Subject: Goulburn Poultry Processing Mixed Use Development (SSD 9143) – Response to Submissions (RTS)

Detailed advice to DPE Planning & Assessment regarding the Goulburn Poultry Processing Mixed Use Development (SSD-9143) – RTS

STORMWATER MANAGEMENT PLAN  
PROPOSED PROCESSING FACILITY  
52 SINCLAIR STREET,  
GOULBURN  
WOODLAND RIDGE POULTRY PTY LTD

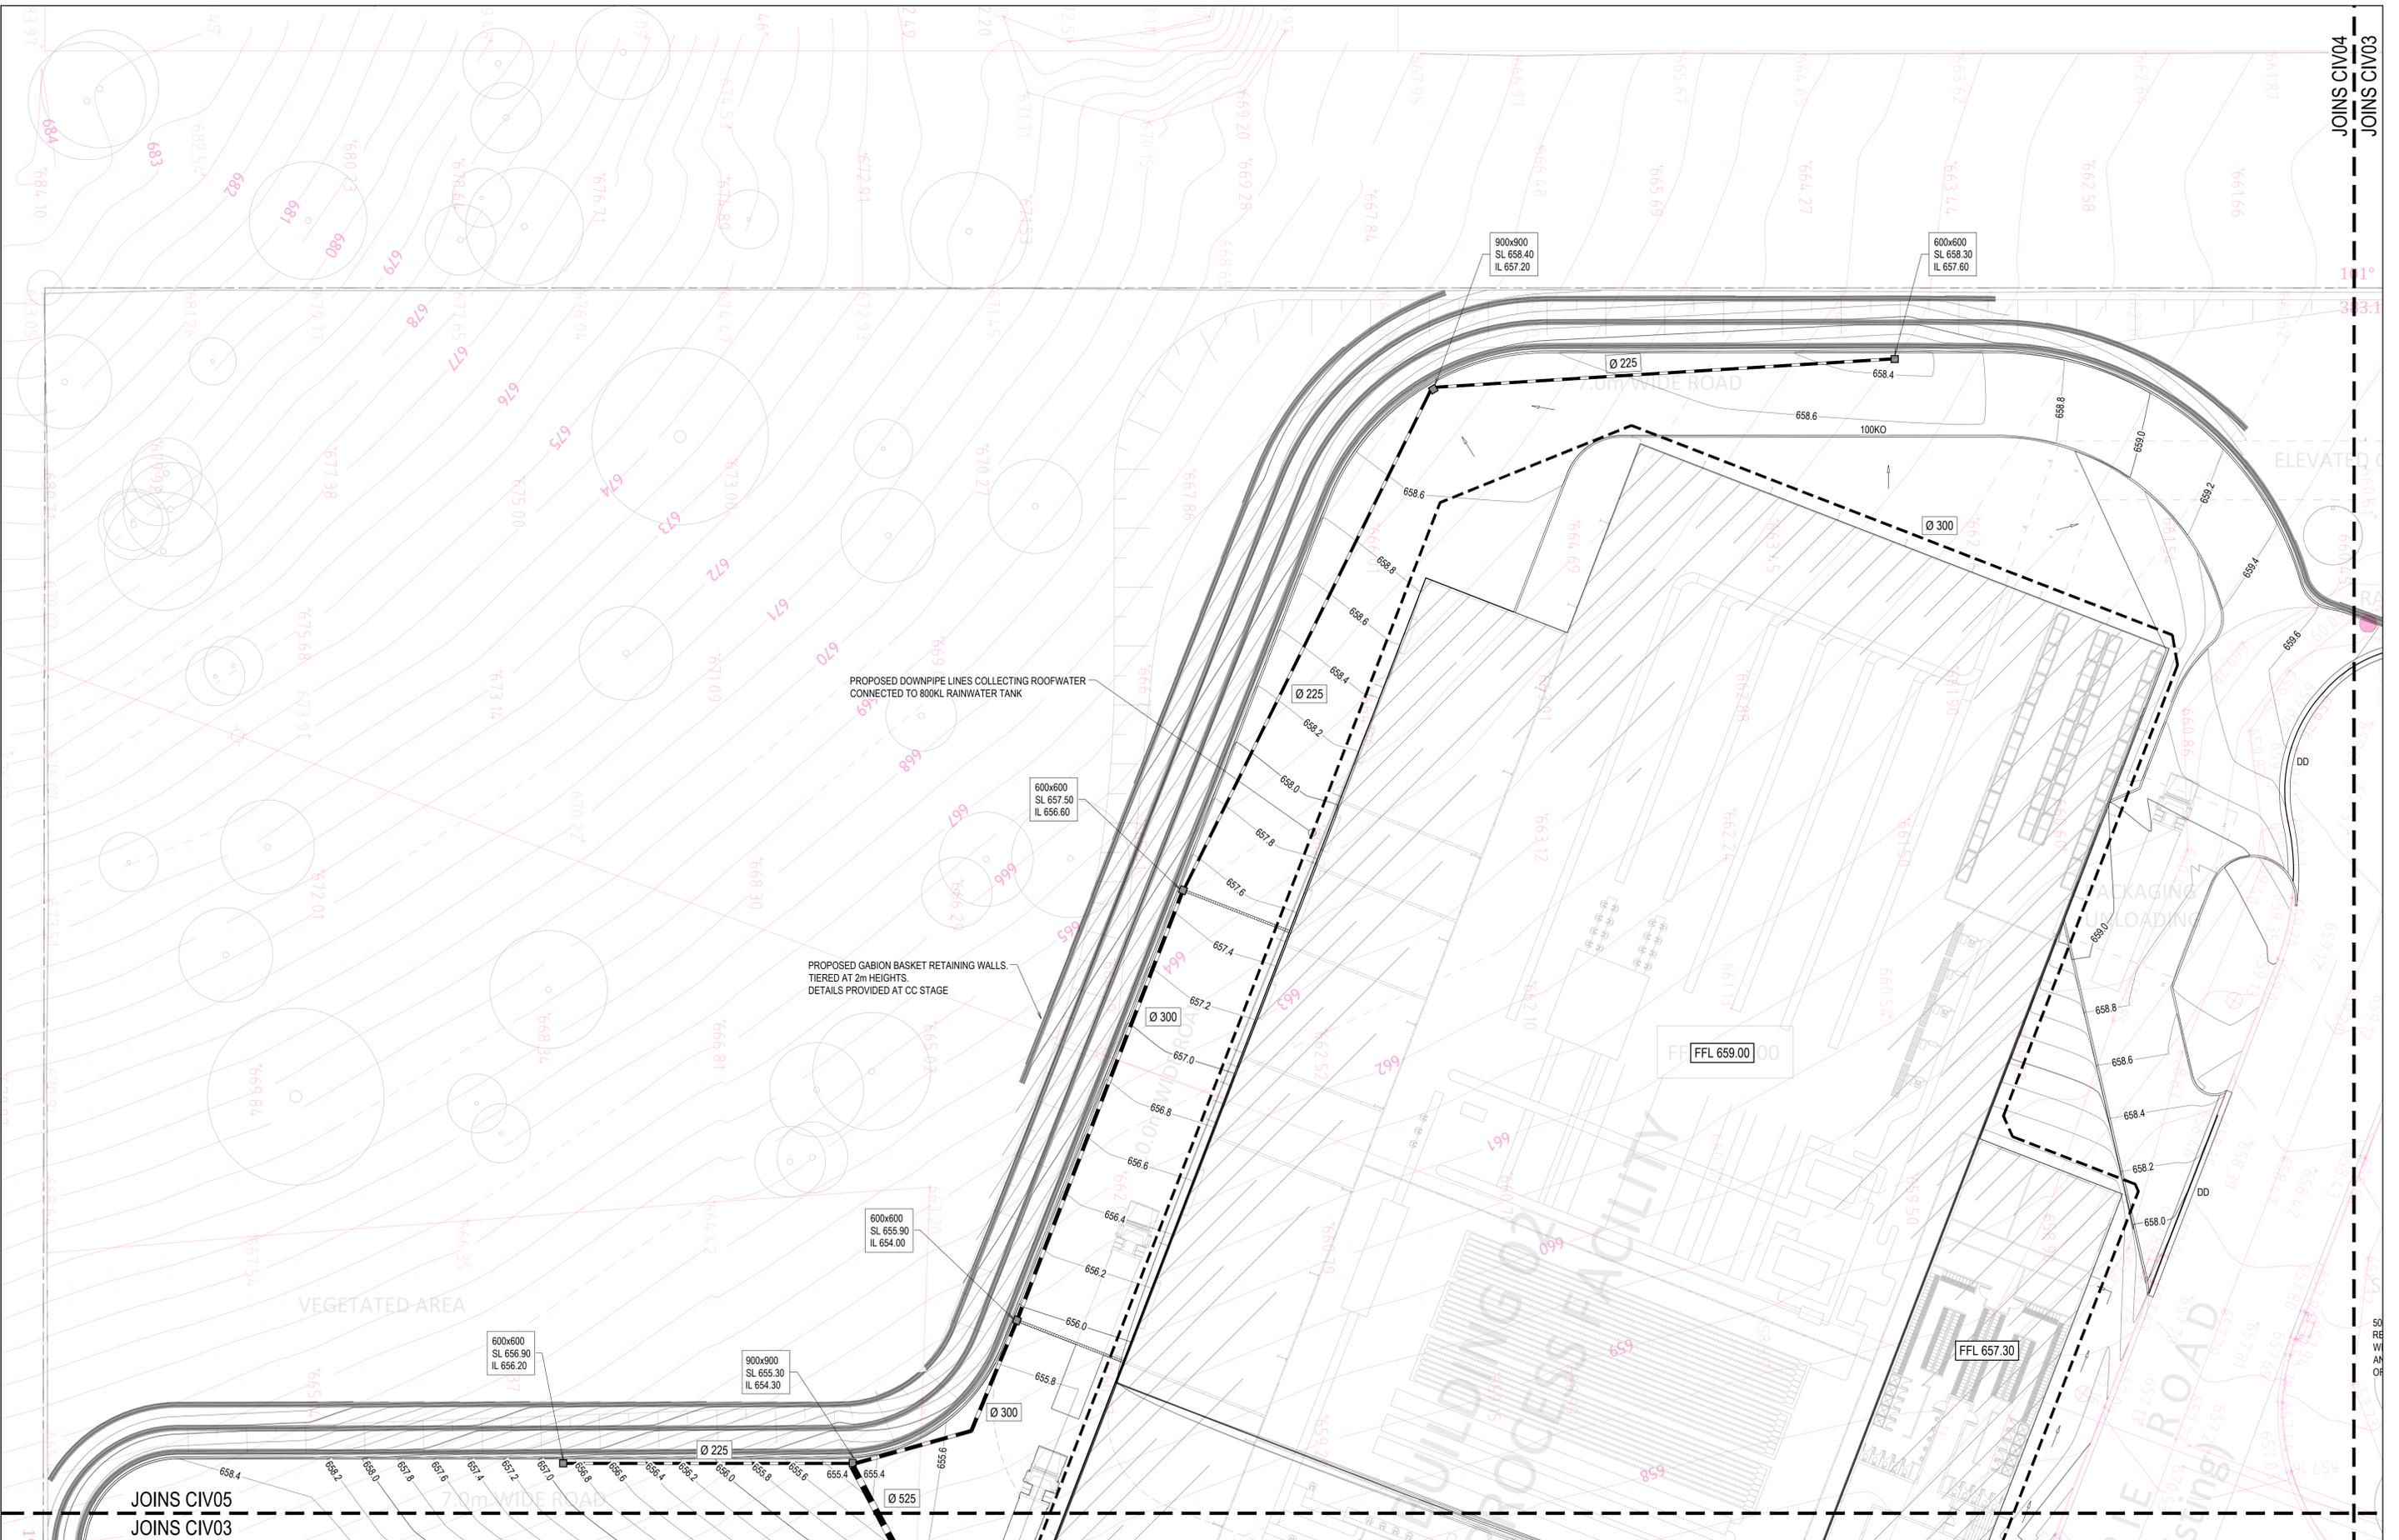
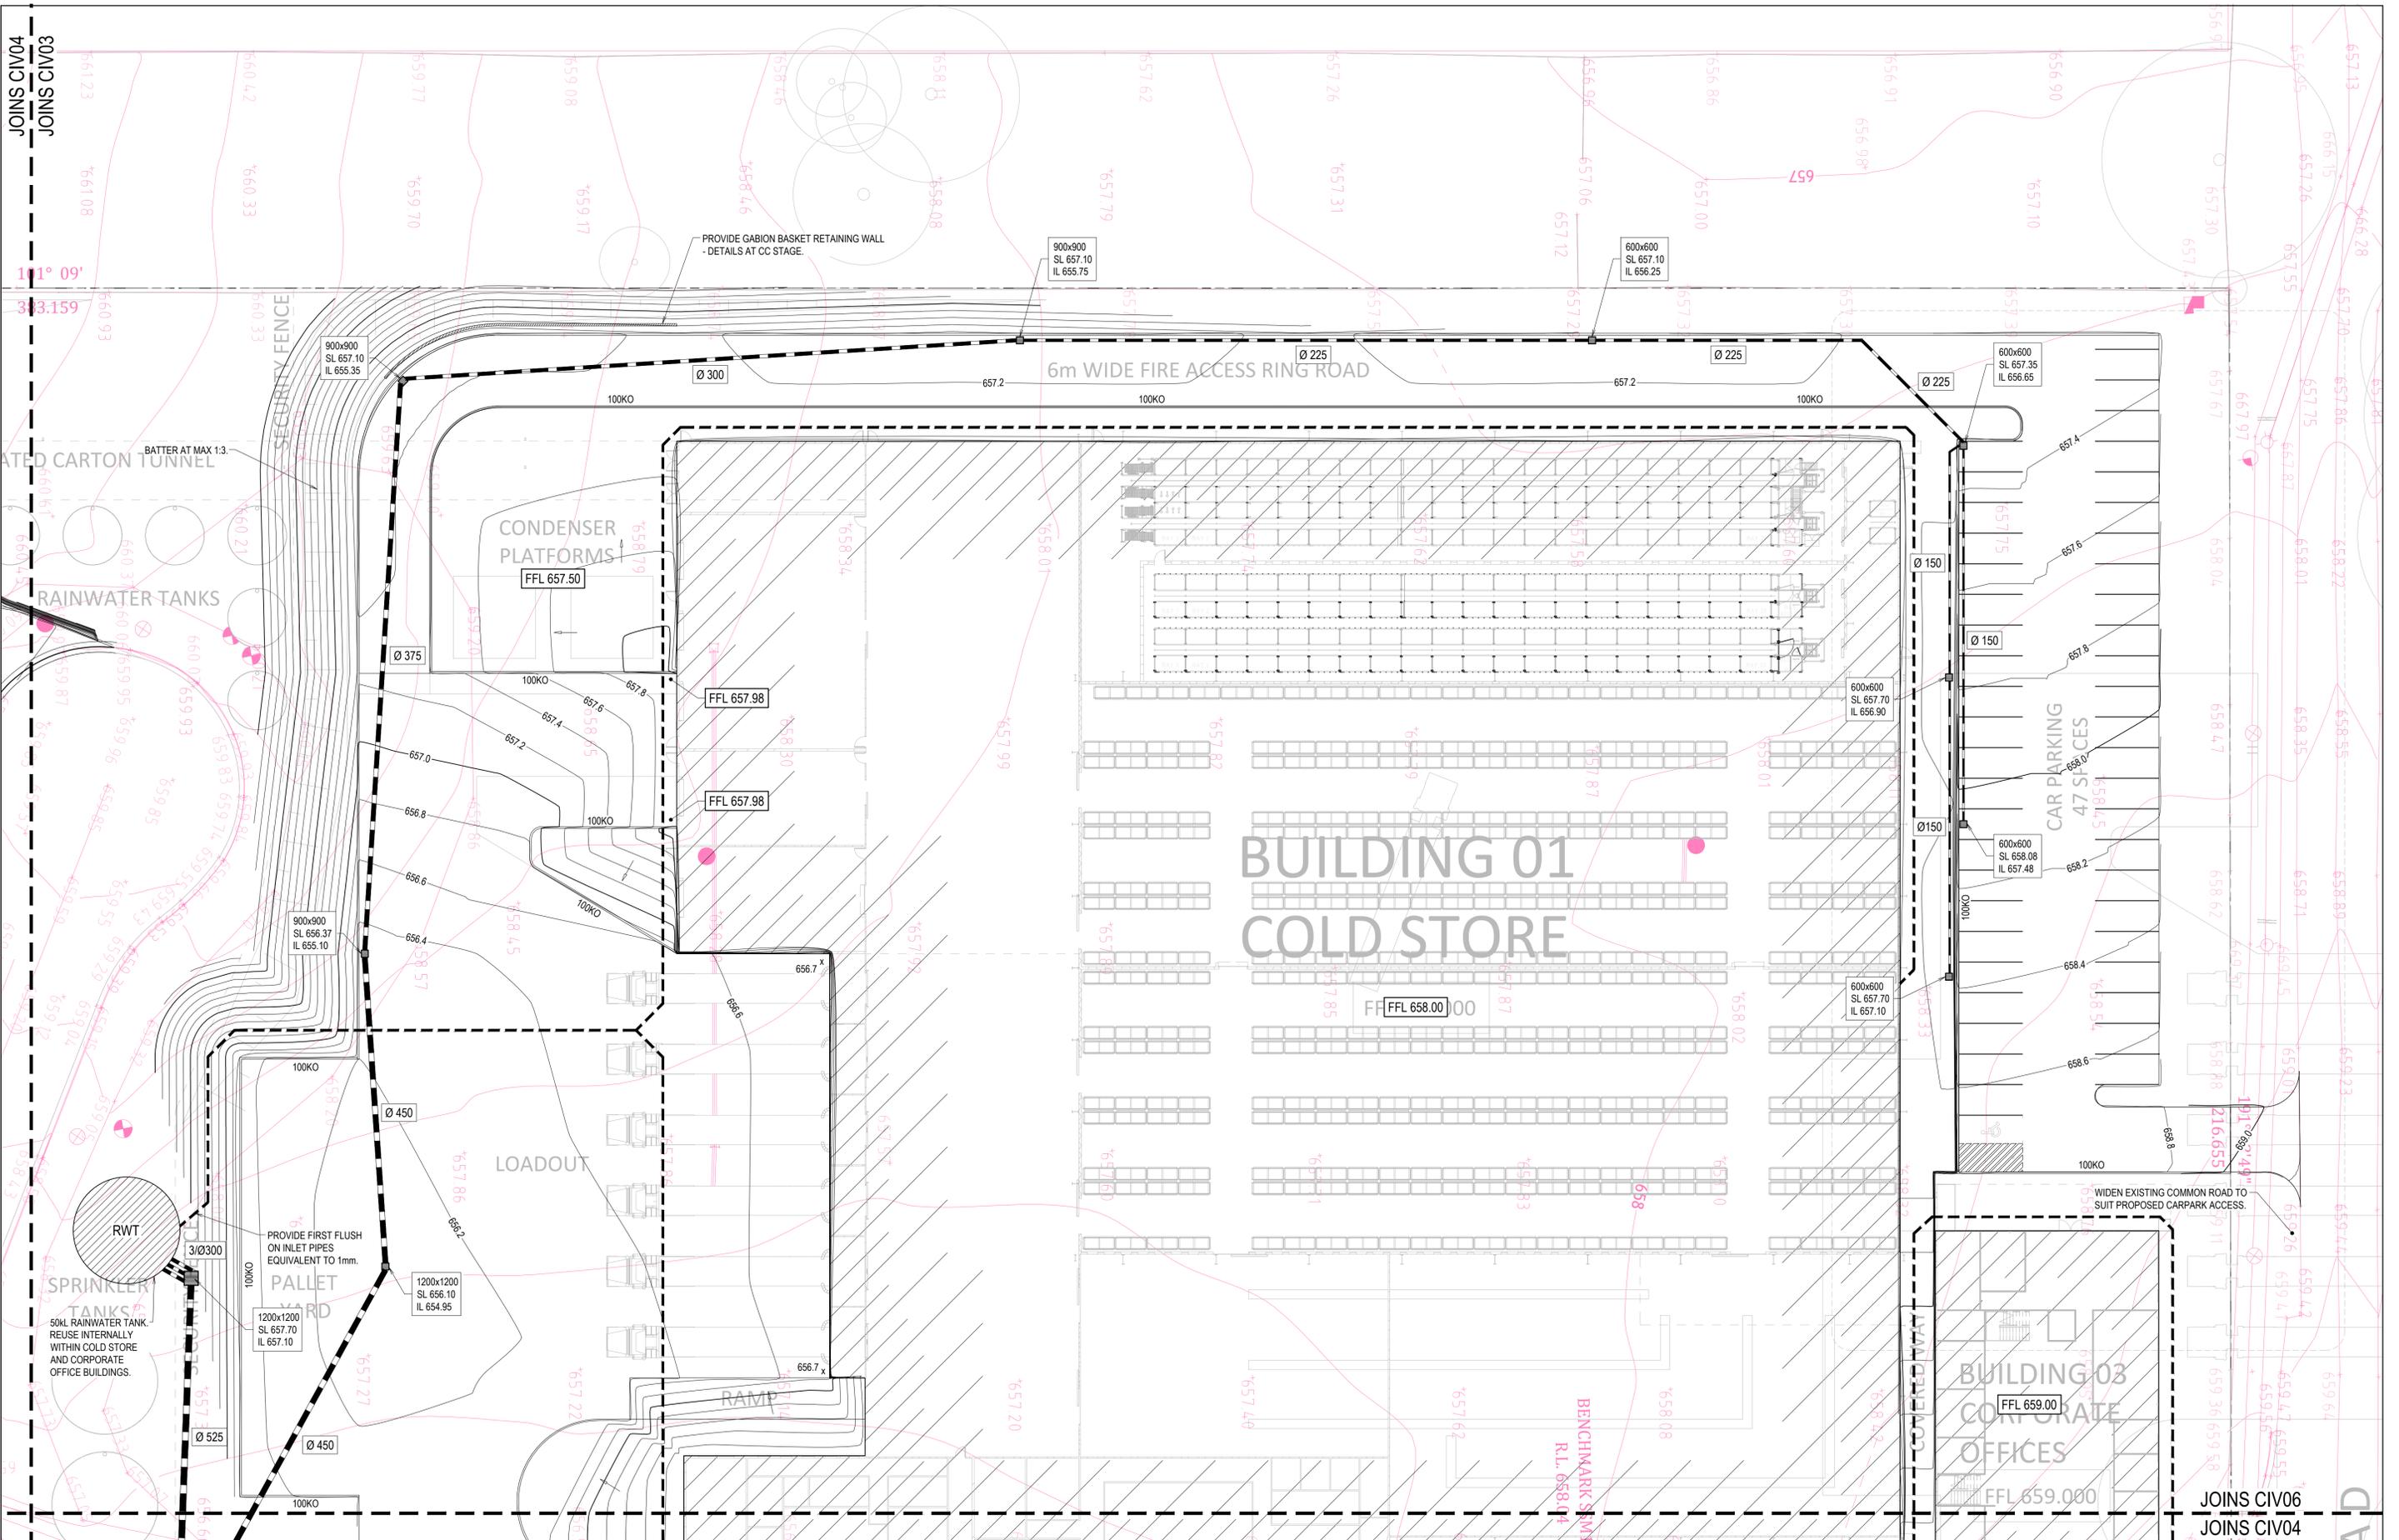
- Appendix B of the RTS provided civil drawings which indicated approximately 10cm of water may be stored in the base of the detention basin. This storage volume is between the base of the basin and the lowest outlet. The capture of runoff in dams on minor streams needs to be considered for licensing under Harvestable Rights or by holding sufficient entitlement in a WAL for water take.

The design of the on-site detention basin needs to ensure that the volume of water that can be permanently held is within the Harvestable Rights for the property or the volume removed from the basin is accounted for by a Water Access Licence (WAL) in the relevant water source.
